Our Ref: Y/83/18/PL

**Town & Country Planning Act 1990 (as amended)
Town and Country Planning (Development Management Procedure) (England) Order 2015
Application for Planning Permission**

Development Change of use to accommodation/ancillary to main house

Location 1 Church Farm Cottages Church Road Yapton

Location Plan 1:1250

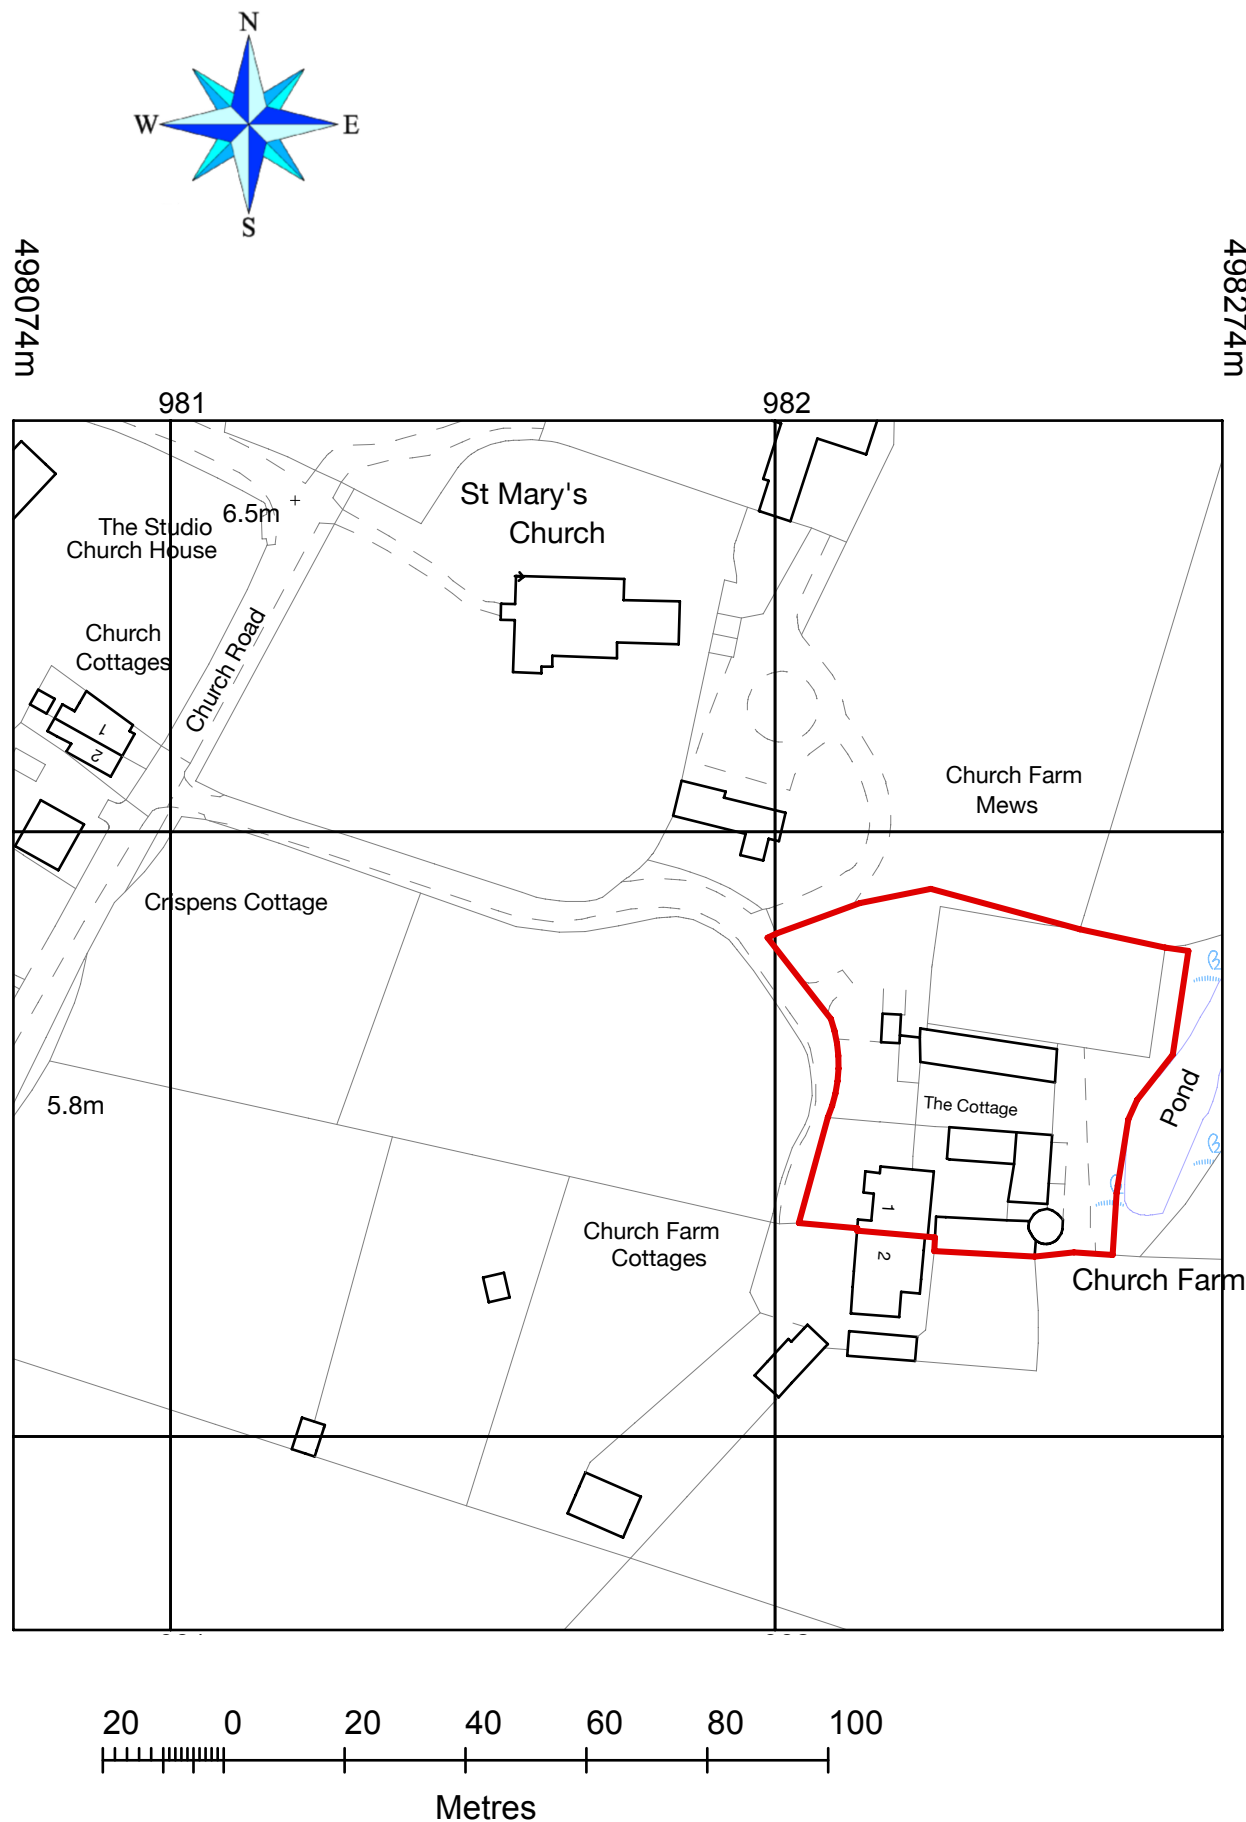
Please confirm the applicant owns all property/land within the red site outline. If not, the certificate of ownership will need amending.

Block Plan 1:500

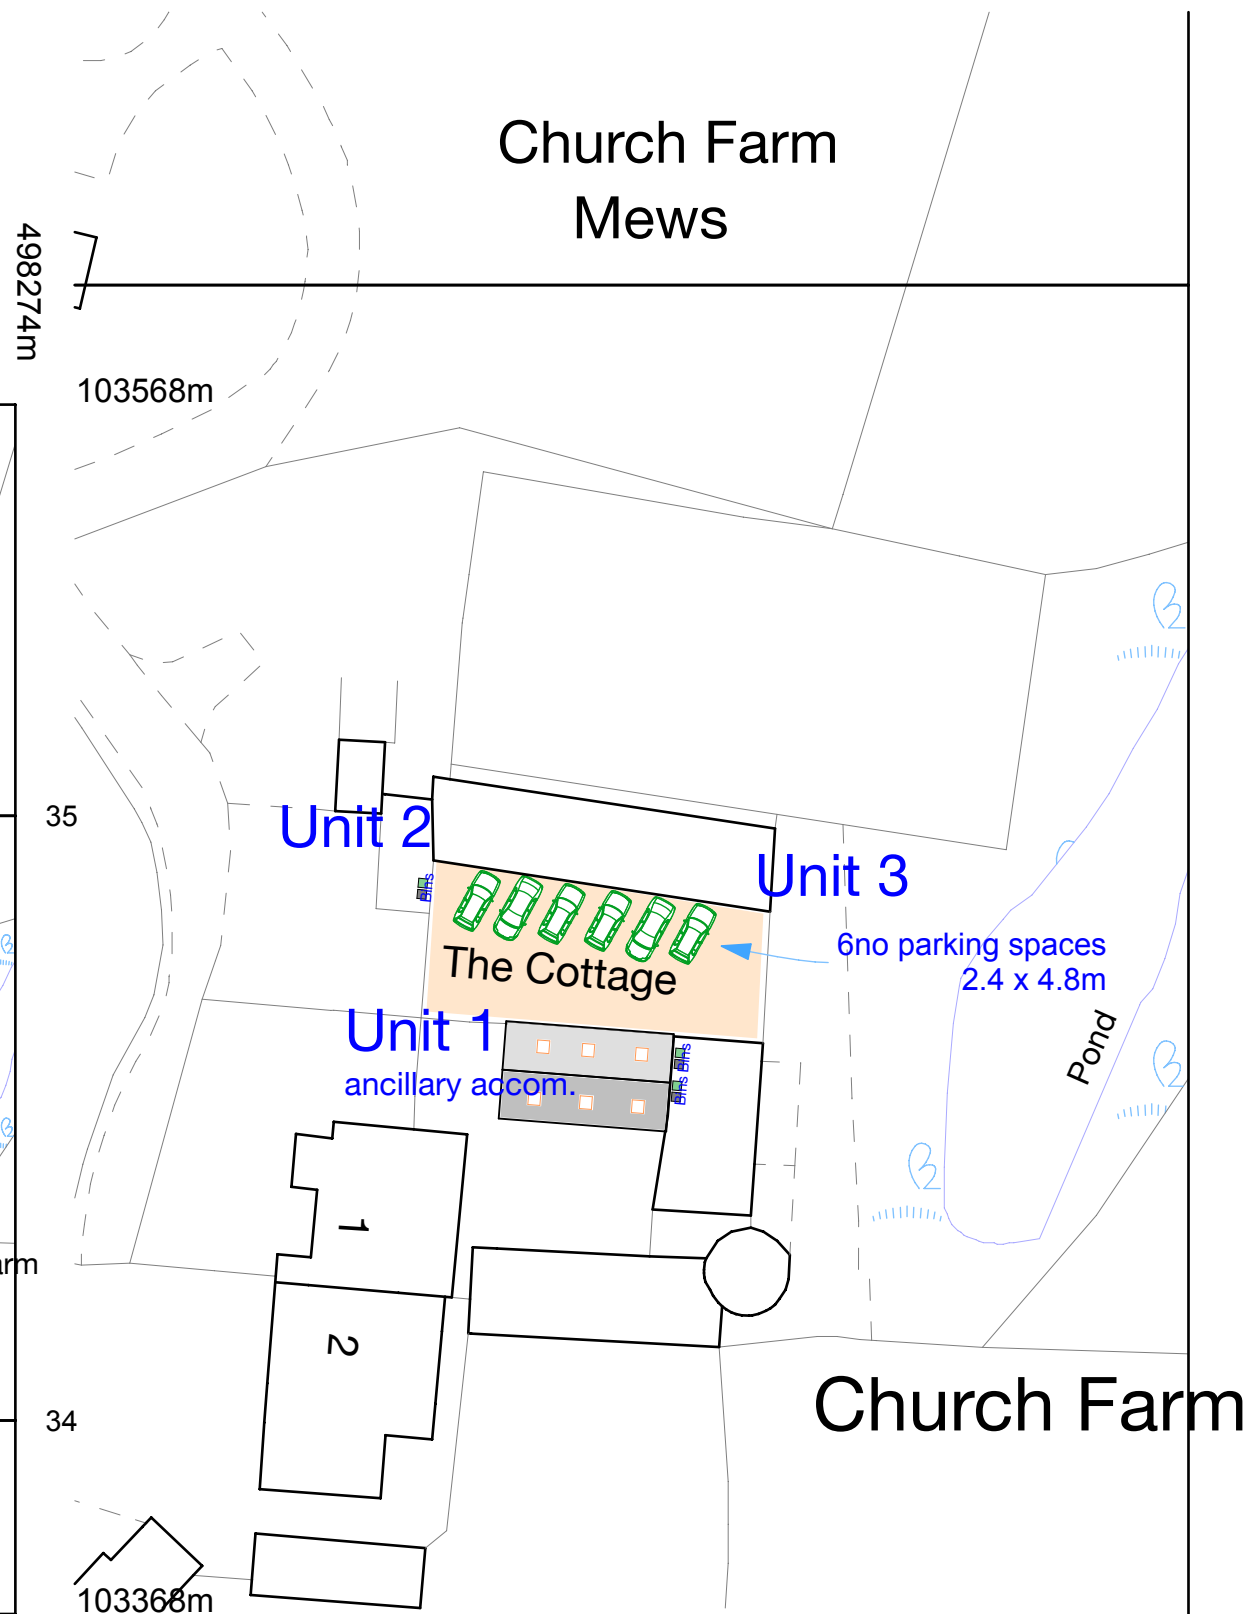
Please confirm the proposal is to be ancillary to the main dwelling, as the block plan is labelled as Unit 1 which suggests it is to be used as a separate unit.
